Approval of details reserved by condition following CM/25/19/PL relation to conditions 3-design & layout of courtyard, 4-schedule of materials & finishes, 6-use of Bat Tubes, 7-Nesting Cups, 10-contamination risk & 12-final verification report demonstrating completion of works set out in approved remediation strategy.

Kents Yard Brookpit Lane Climping BN17 5QT

Arun District Council have decided to **APPROVE details reserved by this condition**

Plan showing detailed design and layout of the courtyard and nesting opportunities

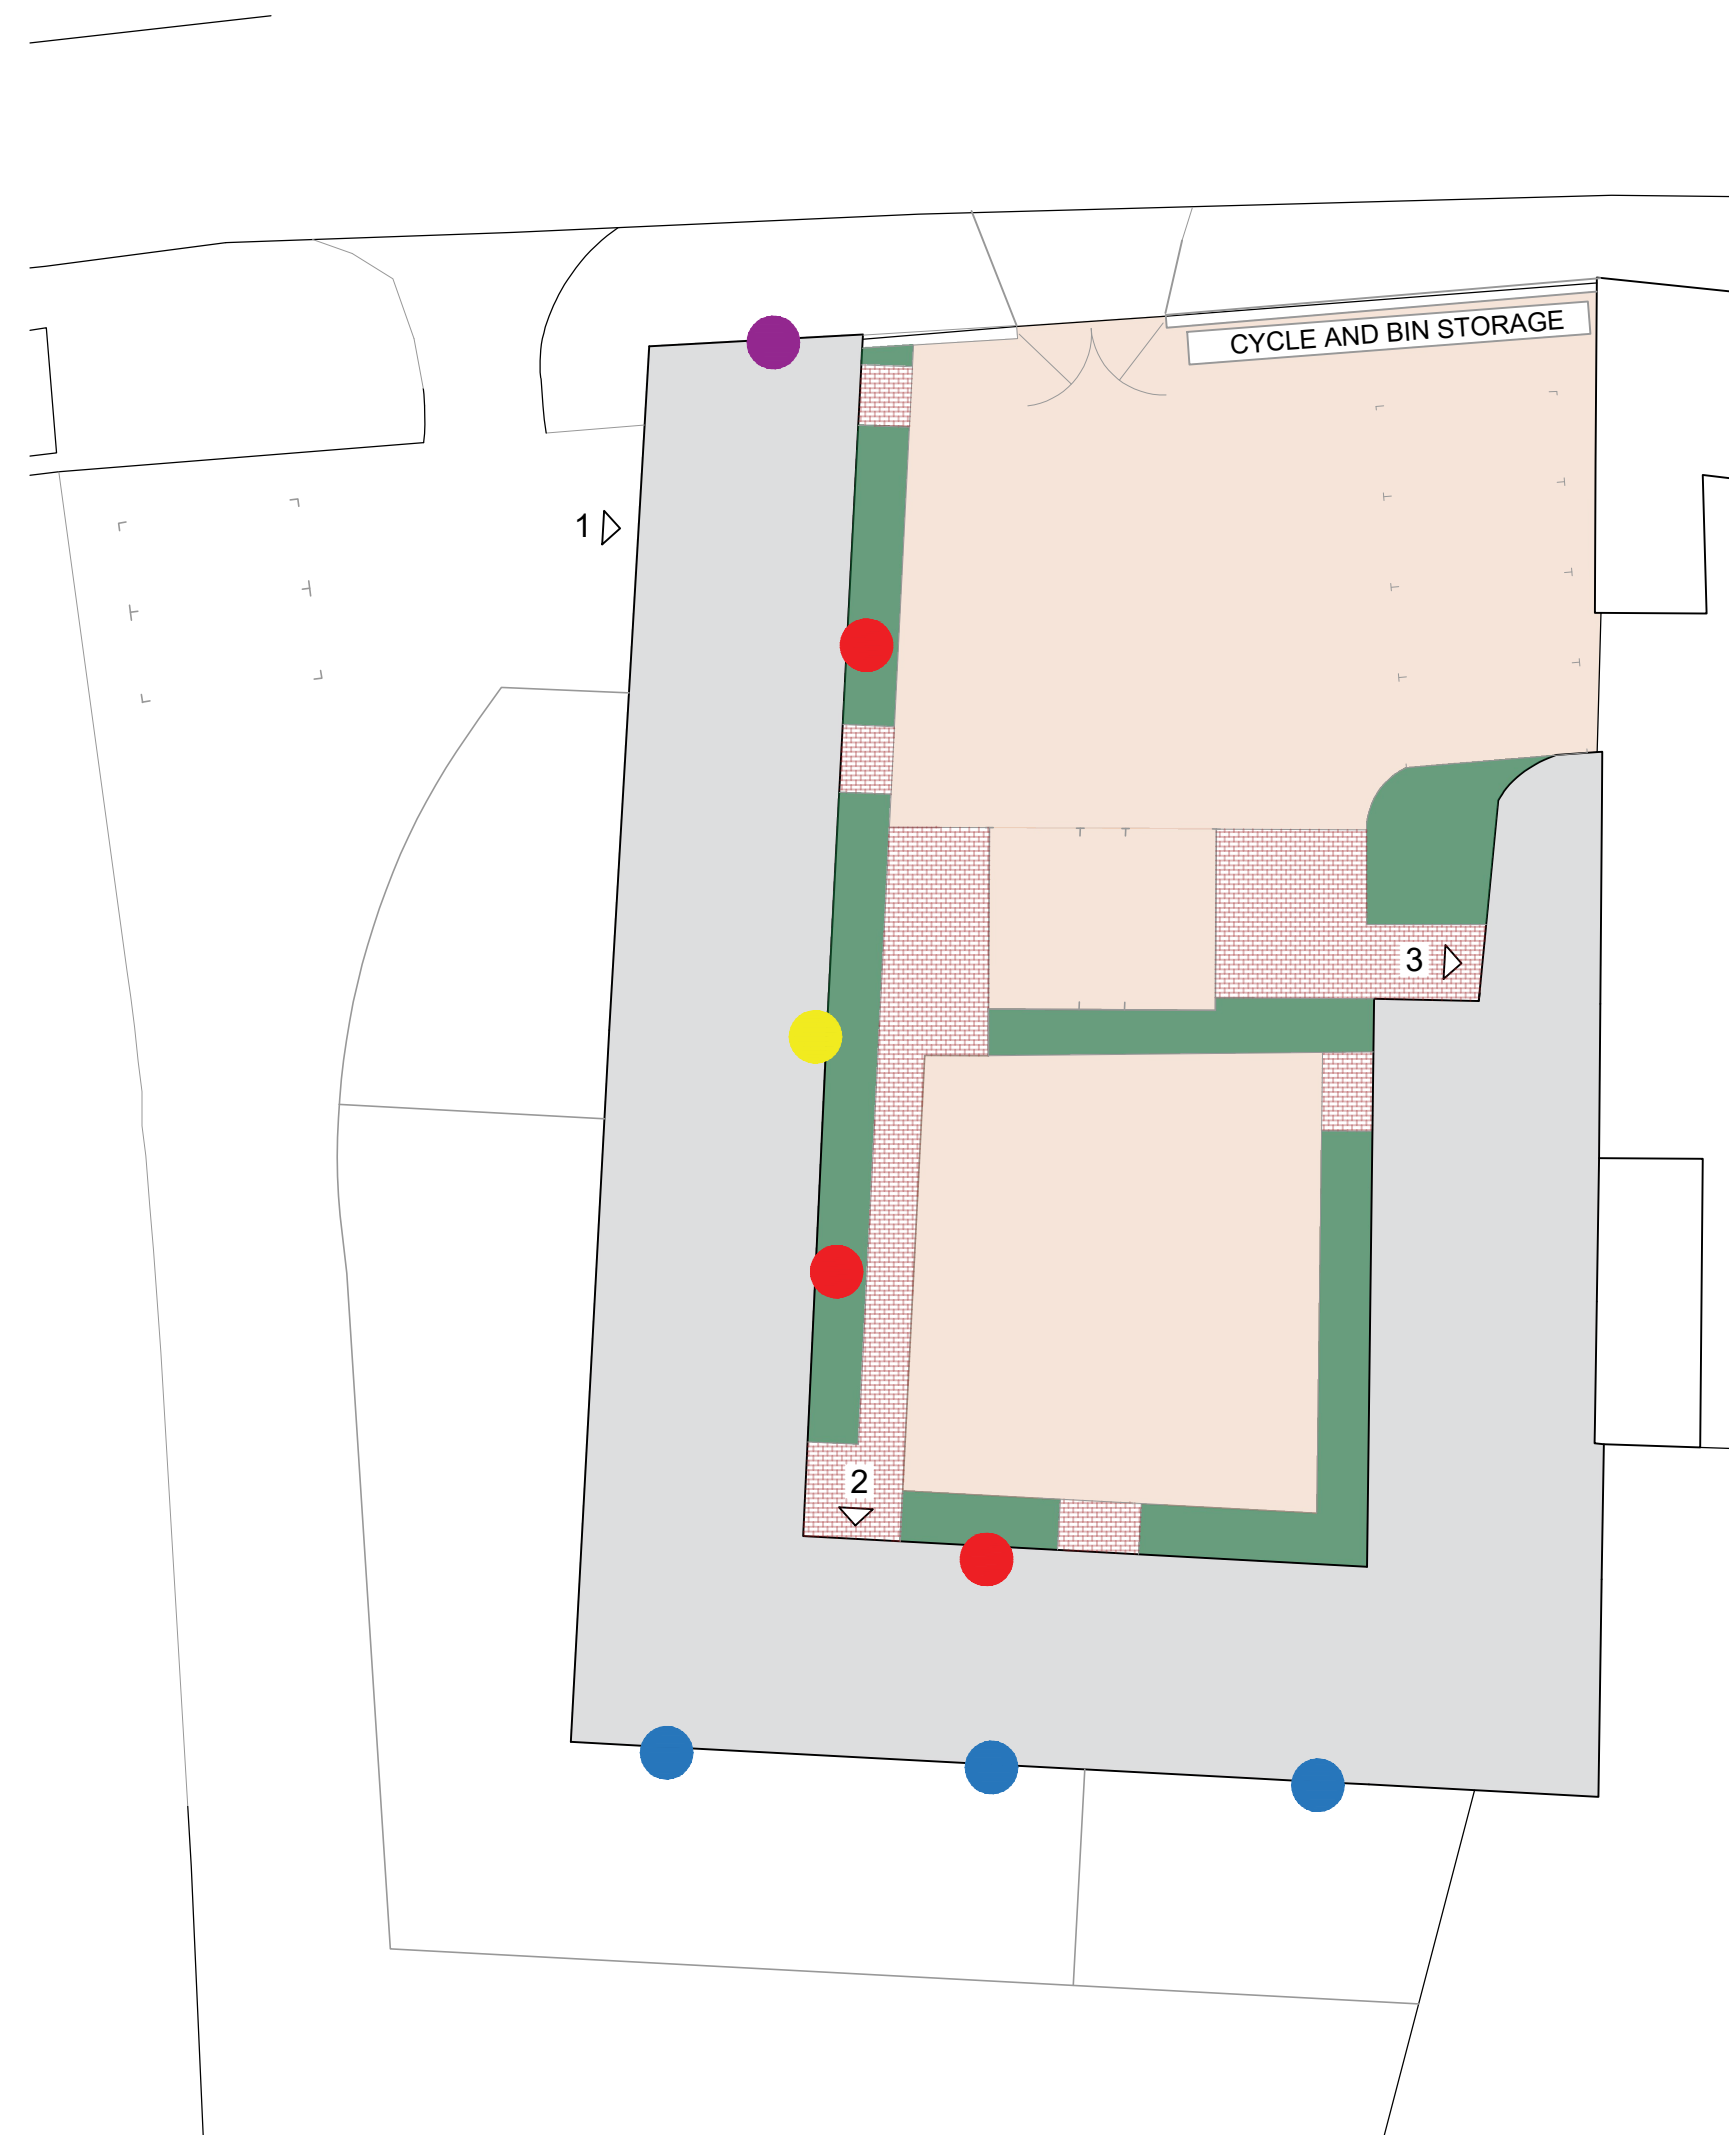
Development shall proceed in accordance with the Bat Survey Report by Batbox limited (May 2016), though a Natural England Licence will not be needed. As a precautionary approach conversion works to the buildings should be undertaken by hand with careful stripping of the internal and external roof space in the presence of a suitably qualified ecologist. If a bat is found all works must stop and Natural England consulted. Temporary roosting opportunities must be made available by installing bat boxes within the trees onsite prior to any construction works. Roosting opportunities must also be incorporated within the conversion as detailed within paragraph 8.3 of the Bat Survey report including the use of bat tubes and such details shall be submitted to the Local Planning Authority for approval prior to conversion works beginning and the development shall proceed in accordance with the details so approved and retained in perpetuity.

This application is discharged in so far as submission of details relates and refers to the bat tubes, particularly Schwegler bat box details indicated on the submitted drawing 1169/FIGURE 1.

Roosting opportunities must also be incorporated within the conversion and the development shall proceed in accordance with the details hereby approved and retained in perpetuity.
